DRB Application No.: 04DRB 01746 Project # 1003671  
Project Name: Ladera Business PK  
Agent: Kera Swannick Phone No.: 417.1404

This letter addresses the delegated items for our Site Development Plan for Building Permit approval issued on November 17, 2004.

Date: 15 November 2004  
To: Sheran Matson, DRB Chair  
From: Russell Brito, Senior Planner *RS*  
RE: Project # 1003671: 04DRB-01746

LANDSCAPE

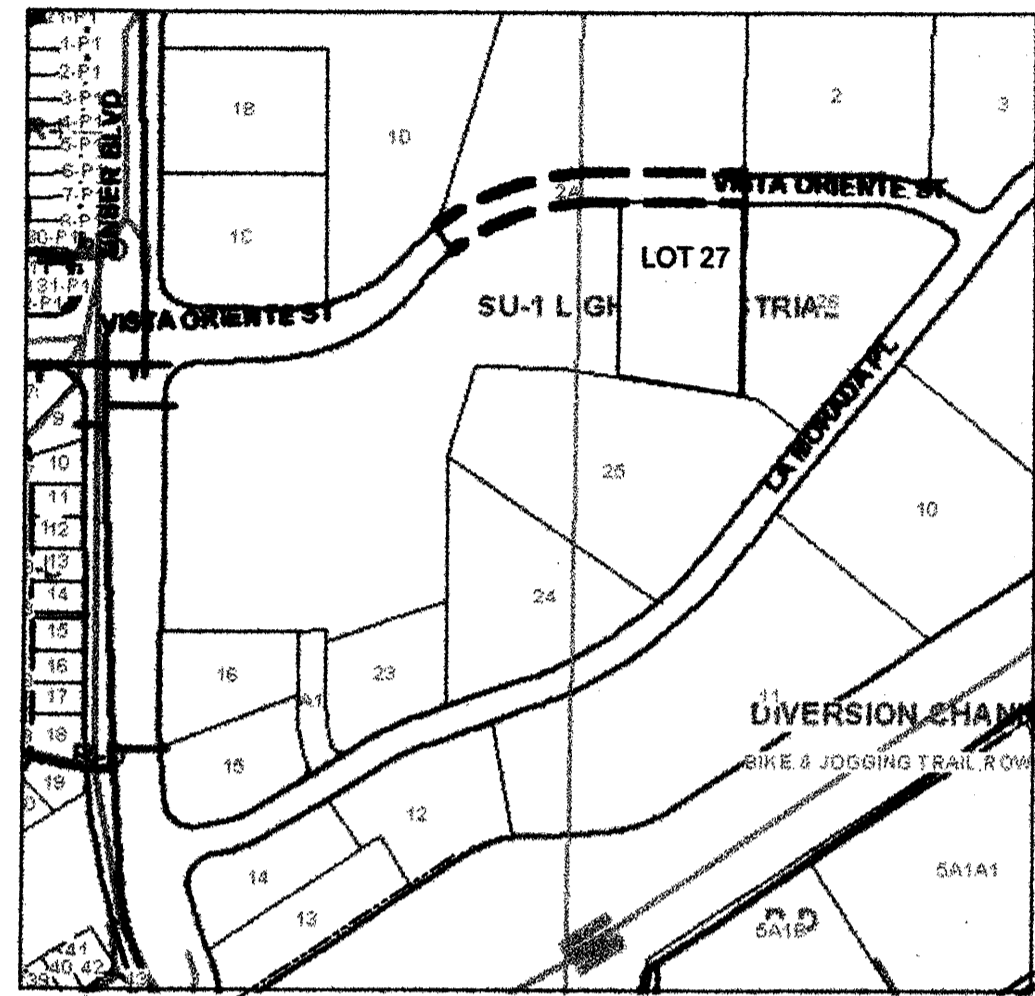
- ✓ 1. A landscaping strip of no less than 10 feet shall be maintained between the parking area and the street right-of-way.
- ② 2. All planting areas not covered with turf shall have a ground topping of crushed rock, river rock, shredded bark, or similar materials, which extends completely under the plant material.

- ③ 3. An automatic underground irrigation system is required to support all required landscaping; describe interim irrigation strategy for future phase and native seed areas needed to establish vegetation and prevent weed infestation.

- ✓ 1 A 10'-0" landscape strip has been added between the parking area and the street right-of-way.
- ② The submitted landscape plan included in the notes: "Landscape areas to be mulched with Santa Fe Brown crusher fines at 2"-3" depth."

- ③ The submitted landscape plan included in the notes: "Plantings to be watered by auto. drip irrigation system." Native seed areas shall be irrigated with a temporary sprinkler system and establishment shall be the responsibility of the property owner. ~~Weed infestation prevention shall be the responsibility of the property owner.~~

Still  
says  
"gravel"

SITE PLAN
Scale: 1" = 20'-0"
10' 5' 0' 10' 20'

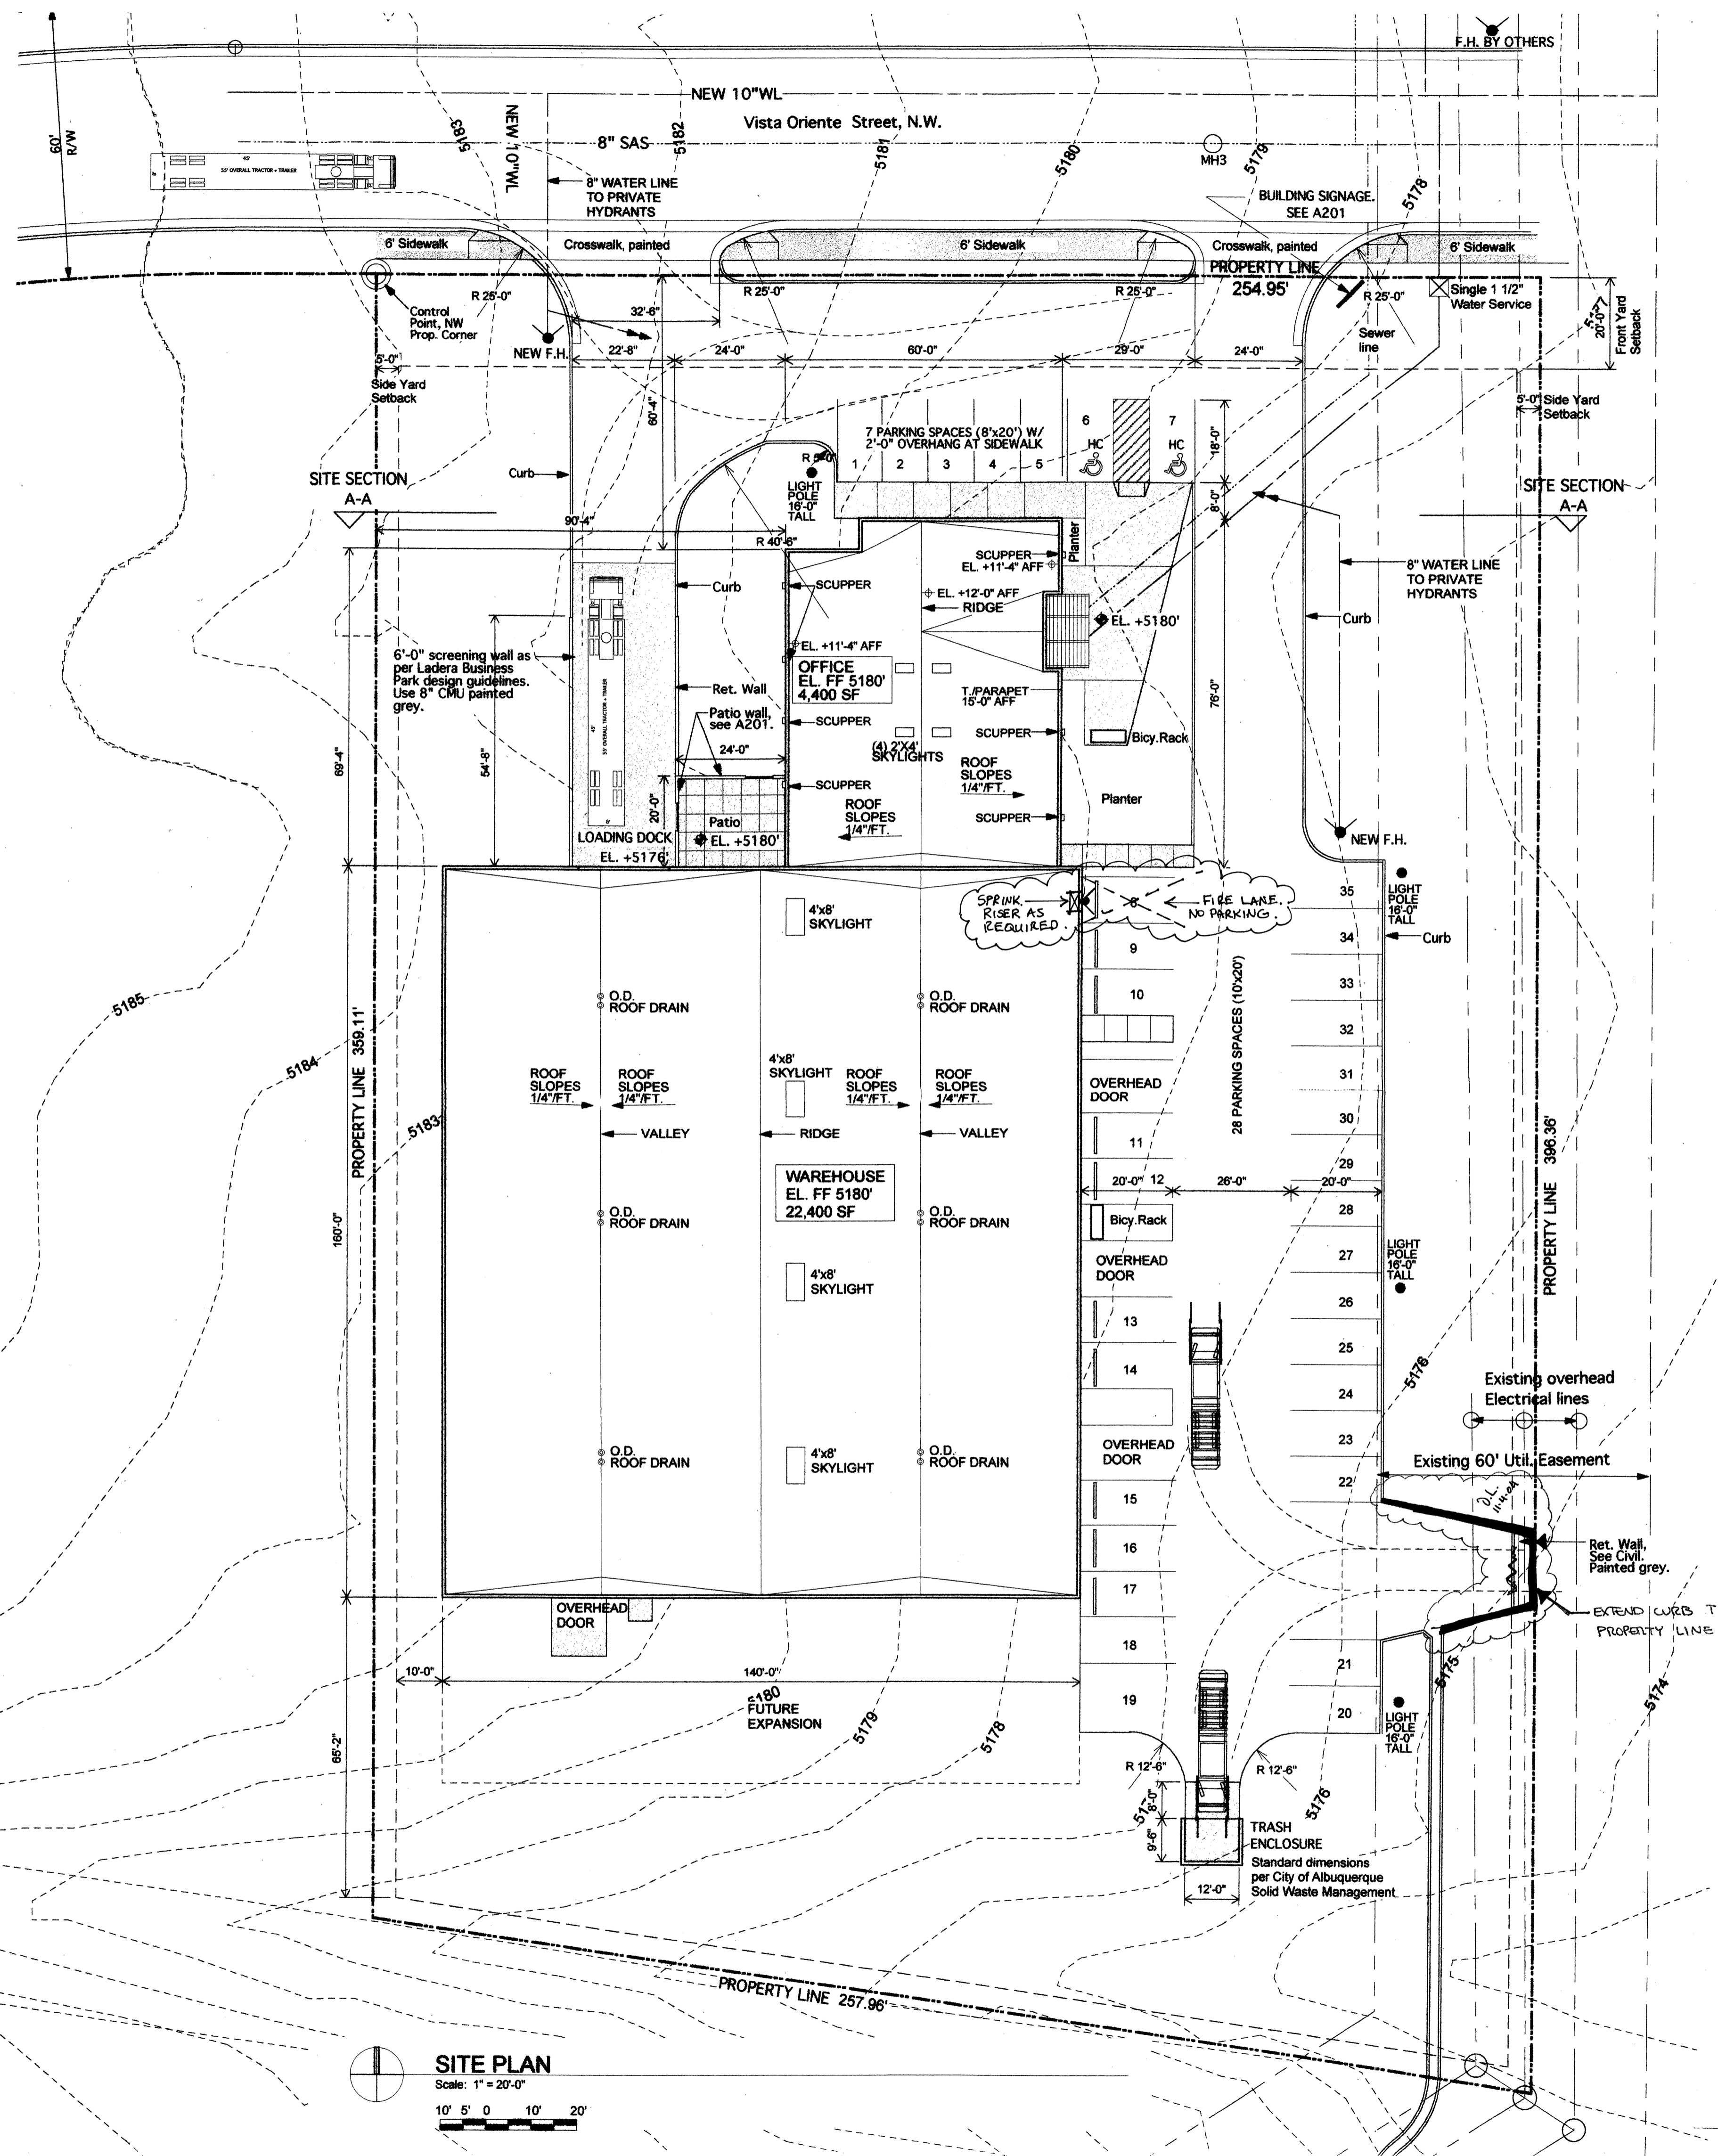
- ✓ 4. Parking areas shall be setback 10 feet from internal roadways (including circulation drives).
- ✓ 5. Show and provide a minimum 6-foot wide pedestrian connection from the sidewalk along Vista Oriente Street to the office building, clearly demarcated with textured paving.

- ✓ 6. All pedestrian walkways shall have adjacent trees spaced approximately 25 feet on center.
- ✓ 7. A shaded sidewalk, that is a minimum of 15 feet wide shall be provided along the entrance side of the office building.

- ✓ 8. Outdoor patio space needs to be 500 square feet minimum with seating, tables and shade provided by trees and/or a shade structure.
- ✓ 9. The parking area shall be screened from the adjacent street with a combination of plant materials, walls, and earthen berming with a minimum height of 3 feet.

10. Describe 16'-0" light poles as having full cut-off/shielded fixtures or provide a detail drawing.

- ✓ 4 See Item 1 above.
- 5 A 6-foot wide pedestrian connection with textured paving has been provided from Vista Oriente to the office building sidewalk.

- ✓ 6 Trees have been added along the entry sidewalk at 25'-0" on center. The sidewalk directly to the north of the building will be primarily shaded by the building and by a shade tree at the west end.

- ✓ 7 See Item 6 above.
- ✓ 8 Outdoor patio has been increased to 500 sf. Seating, tables and trees for shade have been provided. Shade is also provided by the 29'-0" tall warehouse adjacent.

- ✓ 9 Earthen berming (3'-0" high) and plants, in addition to the trees, have been provided in the 10'-0" landscape strip adjacent to the street.
- ✓ 10 Light poles have been deleted. All surface mounted building lighting provided for security shall be fully shielded to avoid any light on adjacent properties or right-of-ways.
